Mercer Island Center for the Arts (MICA) Transportation Impact Analysis
Review Comments
6/5/2017

Reviewer Contact Info:
Richard Hutchinson
rjh@dksassociation.com

# 77th Avenue SE On-Street Parking Concept

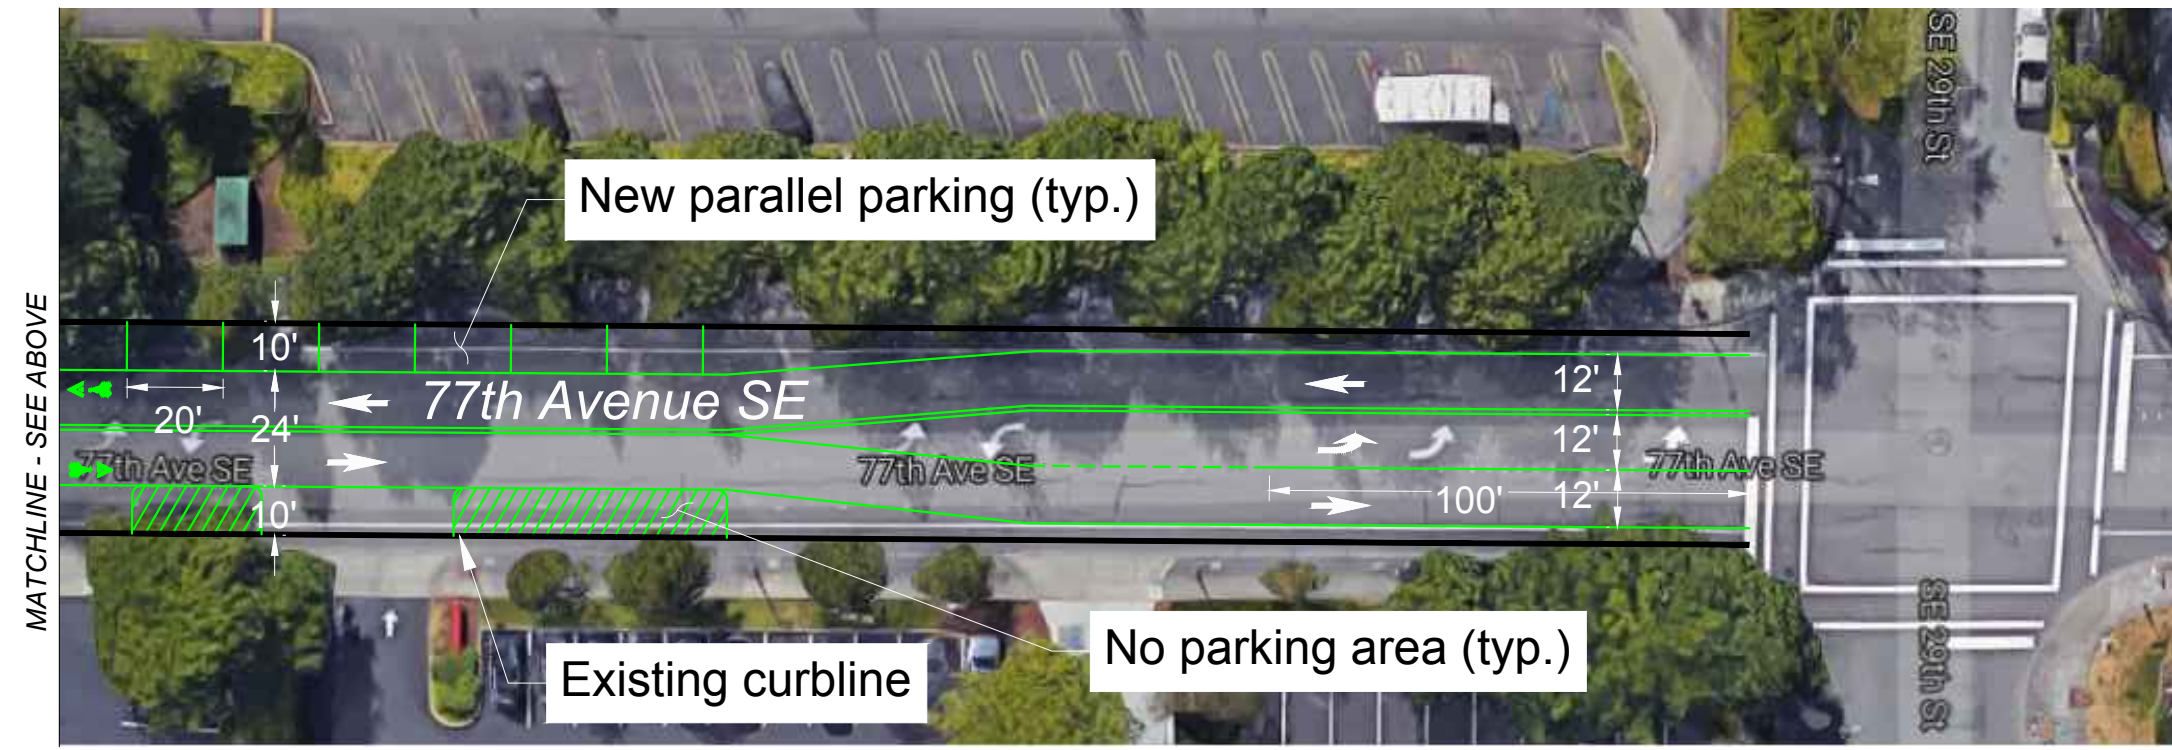
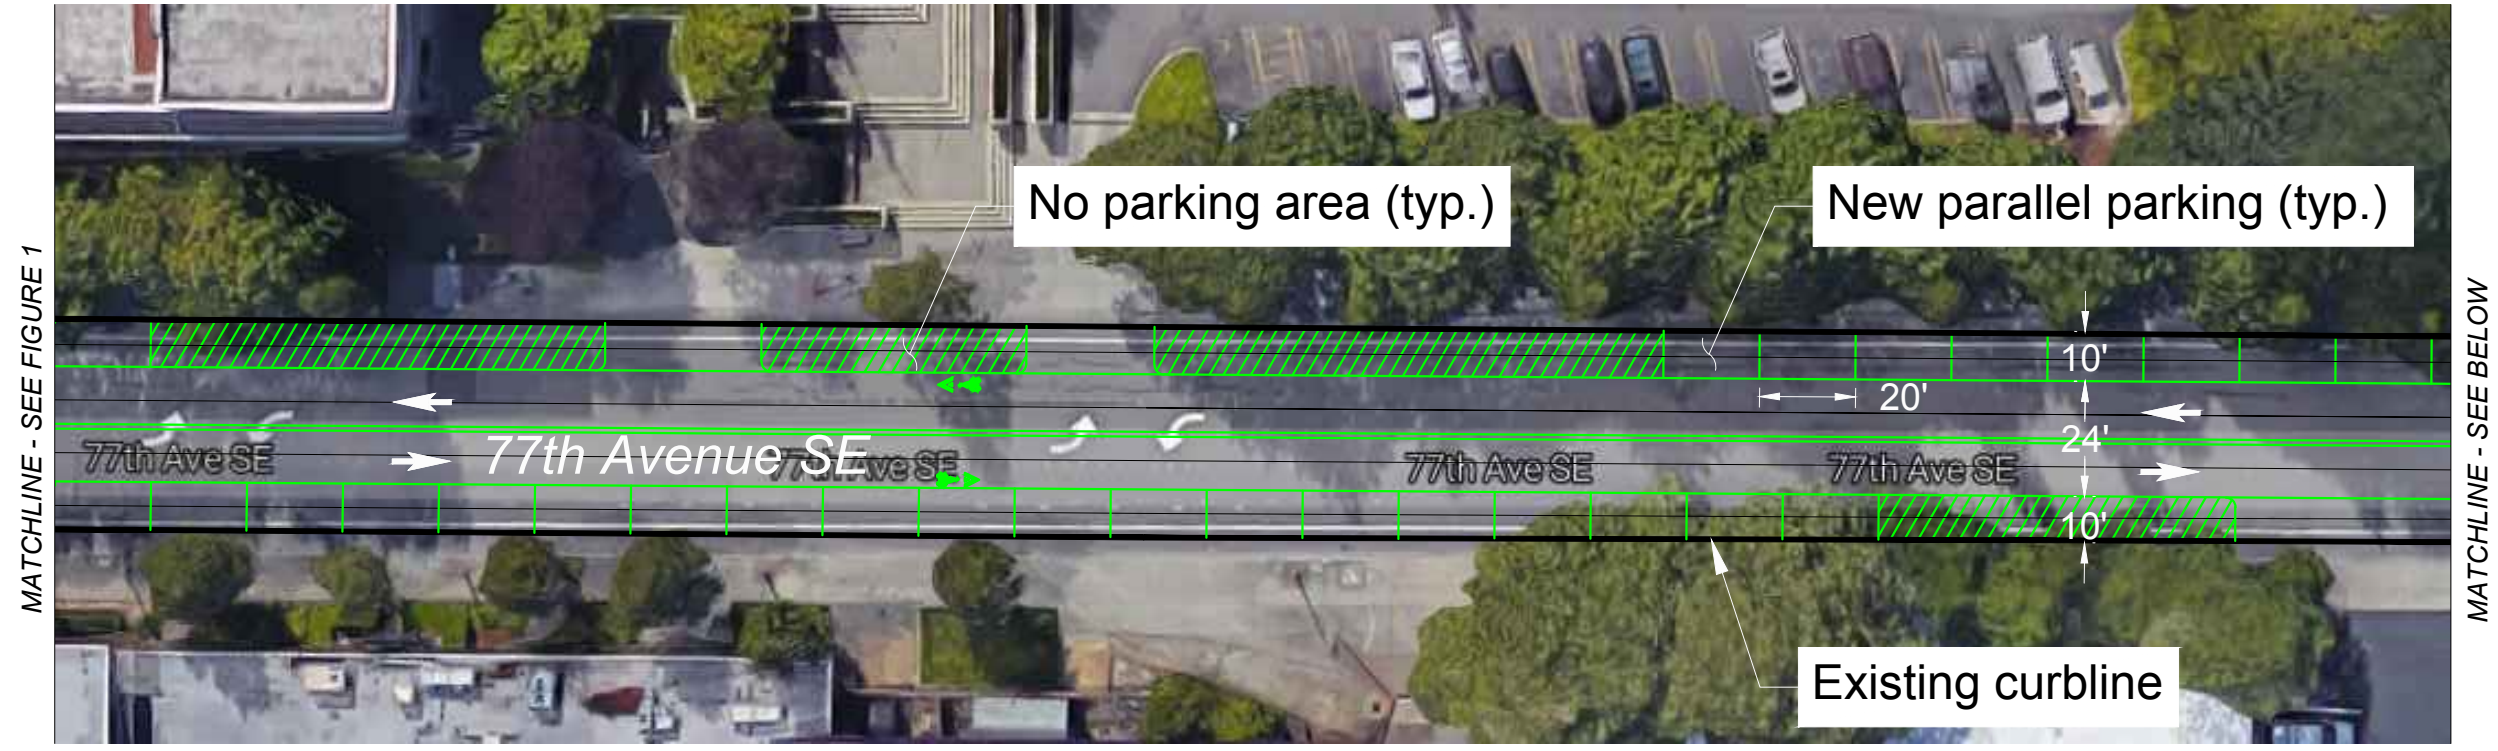
#	Element	Comment	Notes/Response
		<ul style="list-style-type: none">• Transportation Coordinator• TDMP and annual reporting and program adjustments based on reporting• Staff the drop-off/pick-up for efficiency.• Illumination on and off site for pedestrians.• Coordinate facility scheduling with other local events such as Summer Celebration, Farmer's Market, Parks events, and the Thrift Shop.• Restriction of patron parking in the neighborhood south of Mercerdale Park, monitor parking• What to do when/if parking agreements are terminated or cancelled (Alternate parking plan as discussed in earlier comment).• Schedule afternoon activities for kids such that only one class has drop-off/pick-up at one time since the pullout area is small.• Illumination at crosswalks and drop-off as needed.• Sign and mark on-street parking wherever they are proposing parking.
